From: Linda Griffiths
Sent: 04 February 2020 14:23
To: DC Support
Subject: FW: SW Bicester KMC KMD (Persimmon Homes) - LAP Planting and Tree Pit Details

Re 19/02729/DISC
Thanks

From: Tim Screen <Tim.Screen@Cherwell-DC.gov.uk>
Sent: 04 February 2020 10:43
To: Linda Griffiths <Linda.Griffiths@Cherwell-DC.gov.uk>
Subject: SW Bicester KMC KMD (Persimmon Homes) - LAP Planting and Tree Pit Details

Title **Tree Pit Detail**

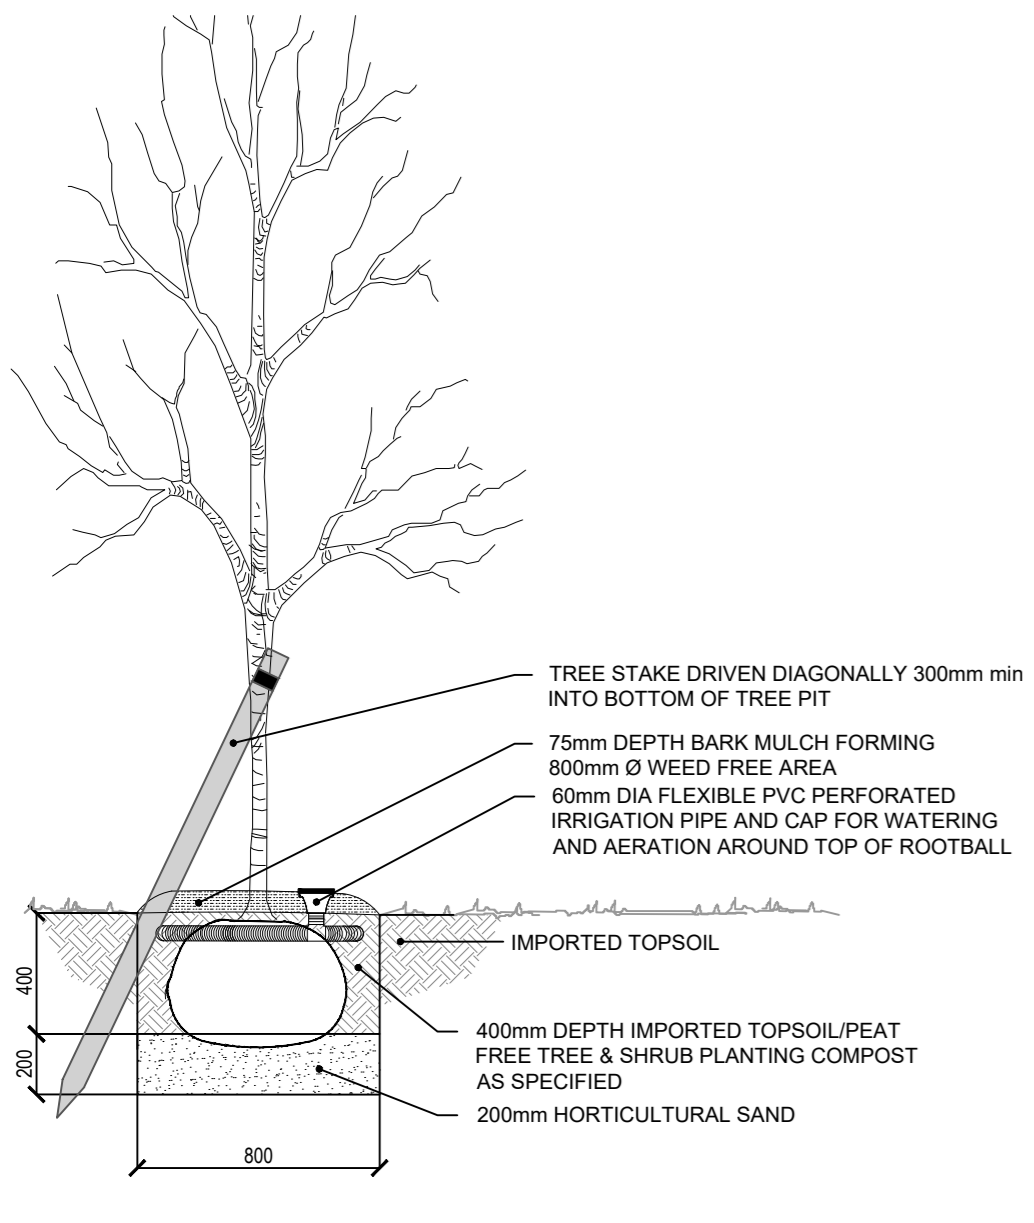
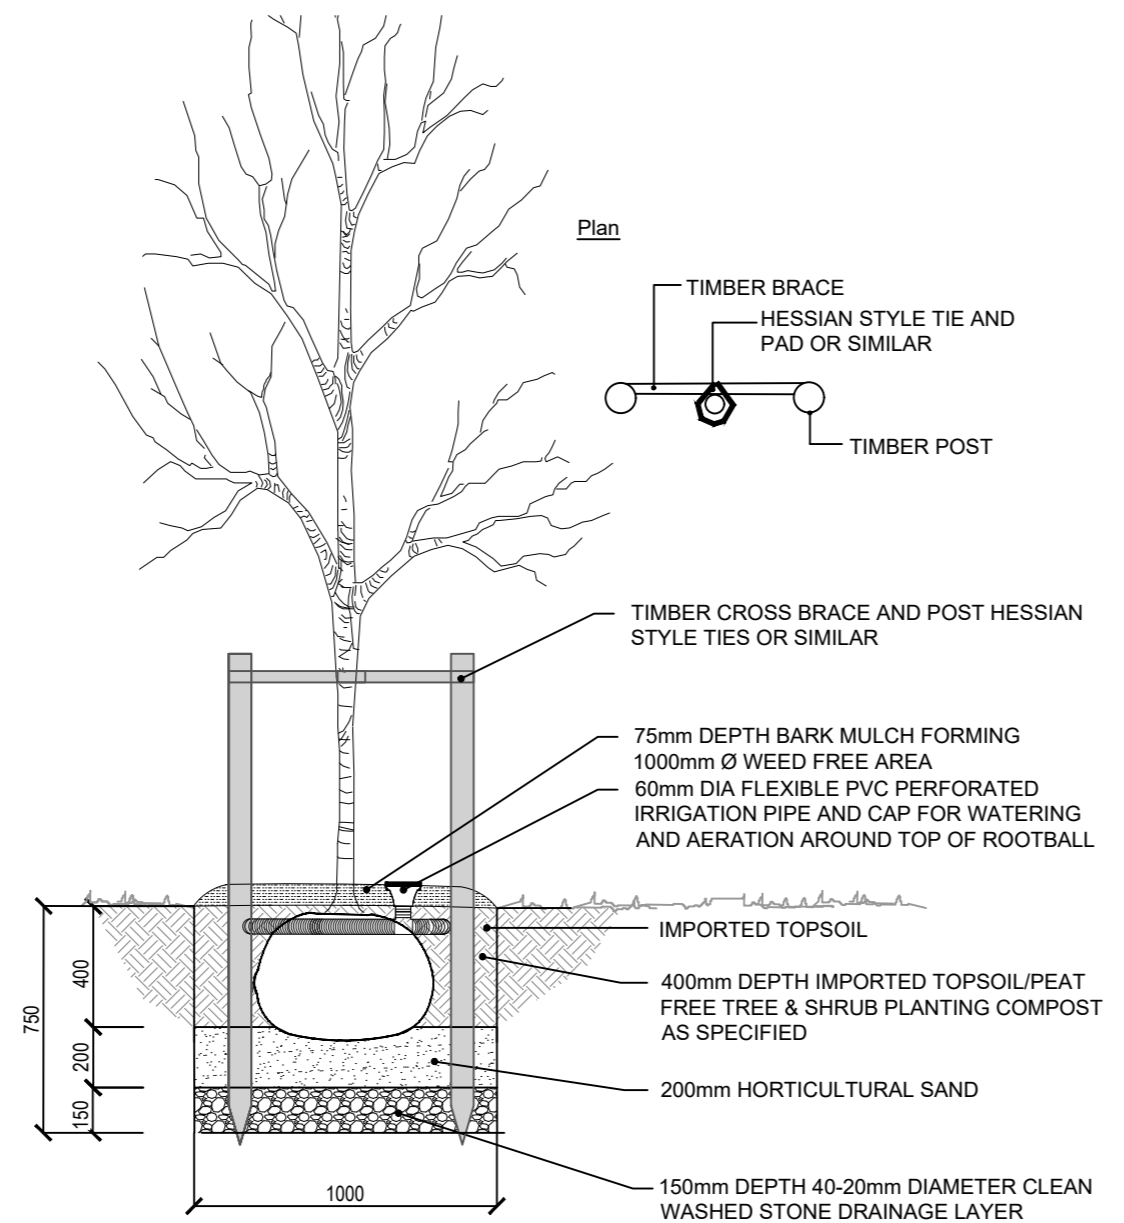
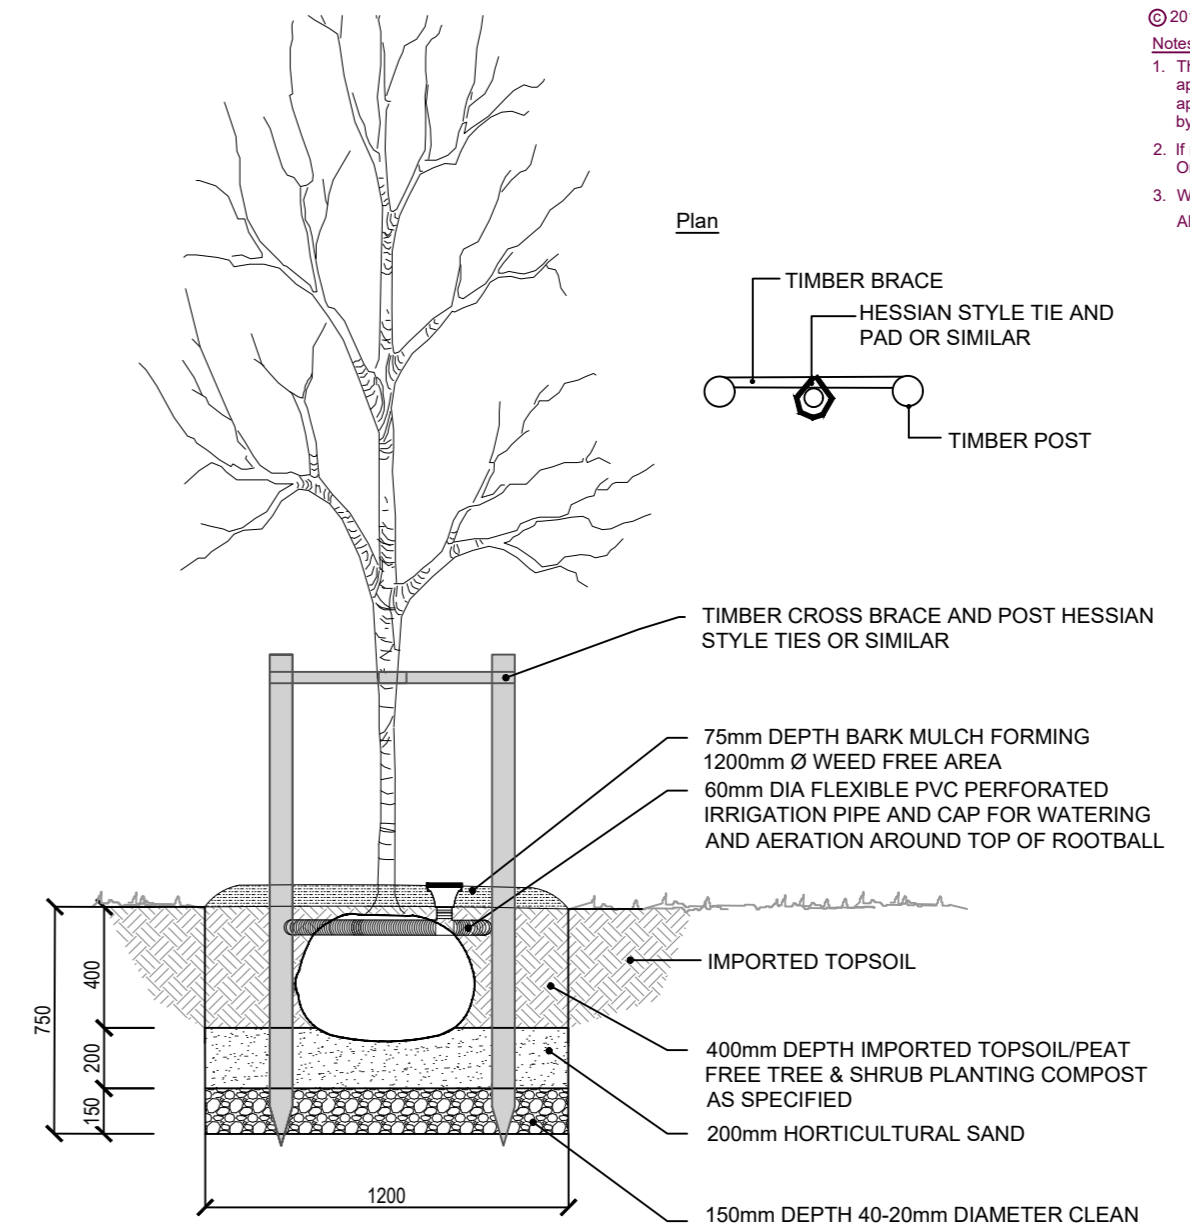
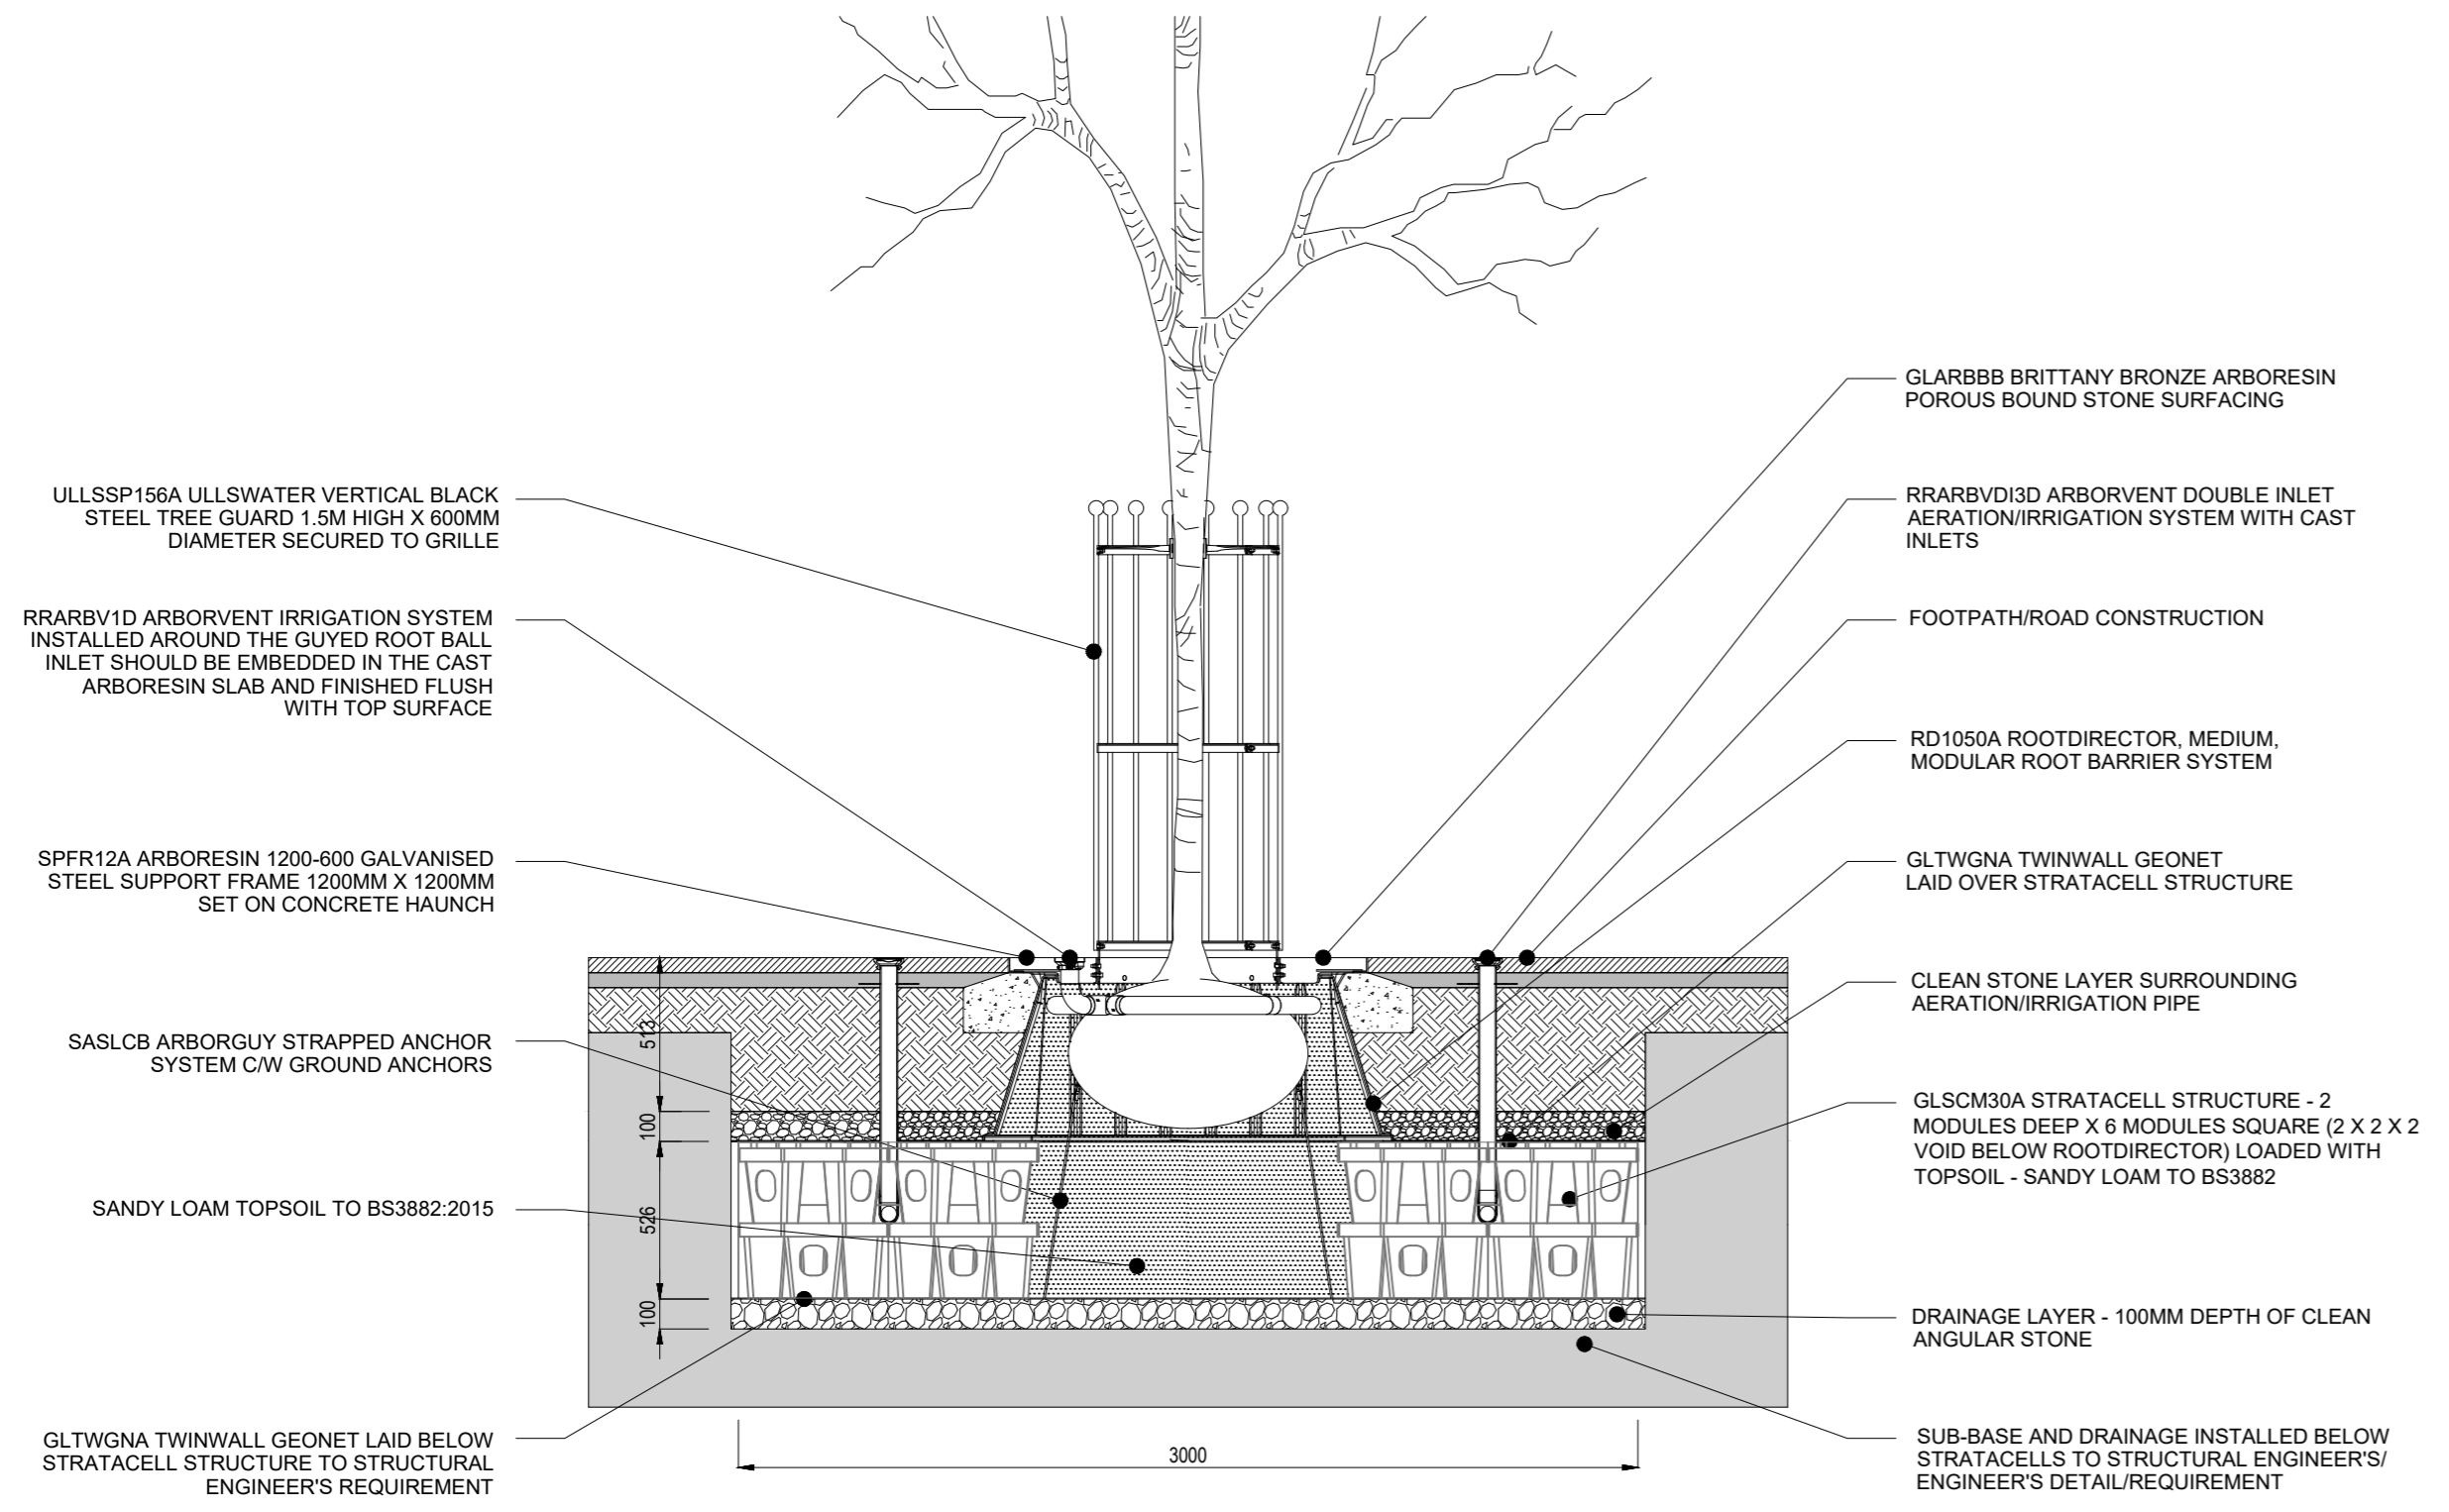
I look forward to the revised landscape proposals for the LAP. The tree pit details are acceptable.
